CITY OF ALBUQUERQUE  
PUBLIC WORKS DEPARTMENT  
UTILITY DEVELOPMENT DIVISION/HYDROLOGY SECTION

September 22, 1993

RE: DRAINAGE PLAN FOR A PROPOSED BUILDING AT THUNDERBIRD STEEL (G15-D44)  
ENGINEER'S STAMP DATED 9/14/93.

THUNDERBIRD STEEL

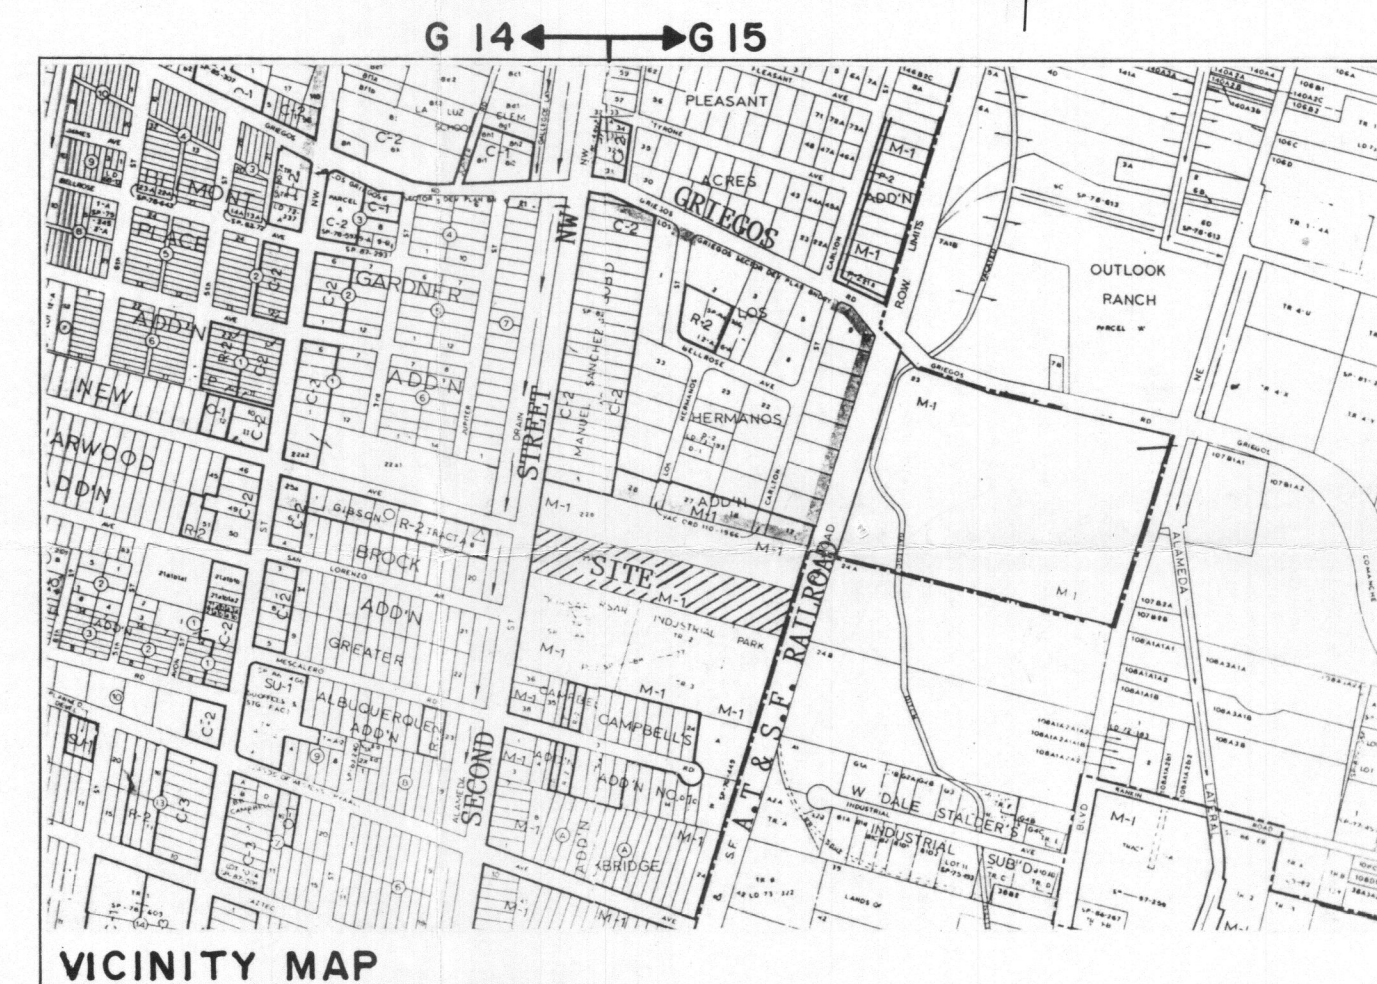
1. Hydraulics for the proposed pipes and inlets. You must compute the inlets in a sump condition.
2. Connection of the proposed 12" R.C.P. must be coordinated through D.R.C.
3. Downstream analysis of the existing 24" R.C.P. must be evaluated to determine to what restriction your proposed development will be held to.
4. Determining your hydraulics of the proposed inlets and pipes and downstream capacity will determine if additional ponding may be required. Existing pond according to your calculation can only hold 56.67%. If the connection to the existing S.D. system can not accept the remaining 43.49% then you must definitely design for additional ponding area.
5. Please included the 100 year water surface elevation on the plan drawing.
